From: planning@welhat.gov.uk
To: [Planning Comments \(Shared Mailbox\)](#)
Subject: New comments for application 6/2022/1508/HOUSE
Date: 21 July 2022 12:16:26

New comments have been received for application 6/2022/1508/HOUSE at site address: The Lodge 2 Northaw Place Coopers Lane Northaw Potters Bar Hertfordshire EN6 4NQ

Org. No. 1605/05	Rev. #
---------------------	-----------

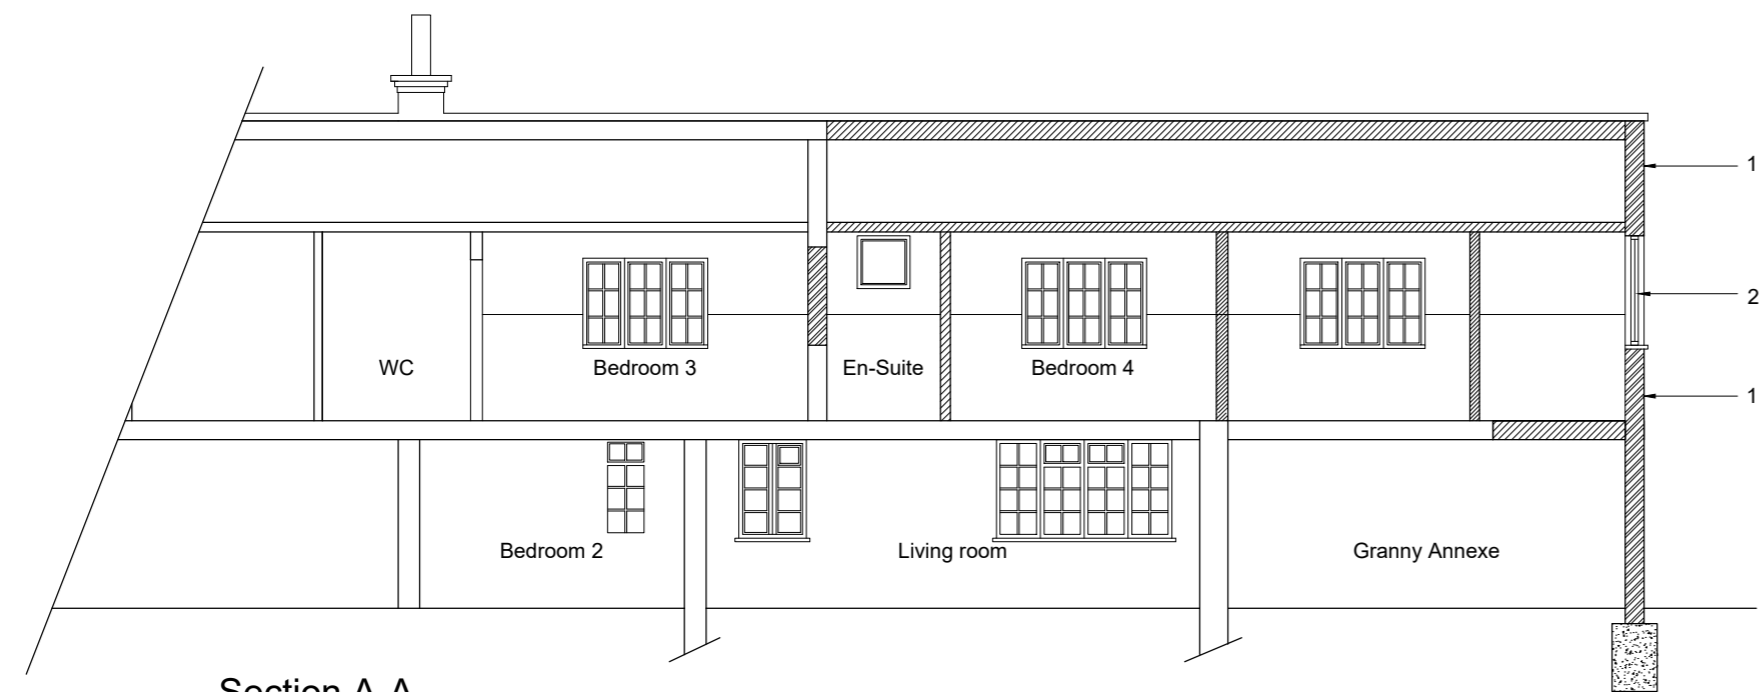
We have no wish to comment on the size, scale or bulk of the proposed extension in green belt. However we would like to note that the proposed changes to the building contextually change the way in which the building overlooks us and reads relative to the main Northaw Place house. At the moment there are just two tiny discrete well screened bathroom windows that overlook our house. The proposed extension adds two very large bedroom windows which change our privacy setting, and actually makes the building read dominantly from that side. These windows have limited opportunity for screening due to the way the driveway is located in the lodge. We must object to the second window which is in the bedroom above the disabled shower. We would ask that this window is positioned where the staircase is, in line with the direction of the current upstairs window and the room reconfigured to accommodate this to reduce the intrusion.
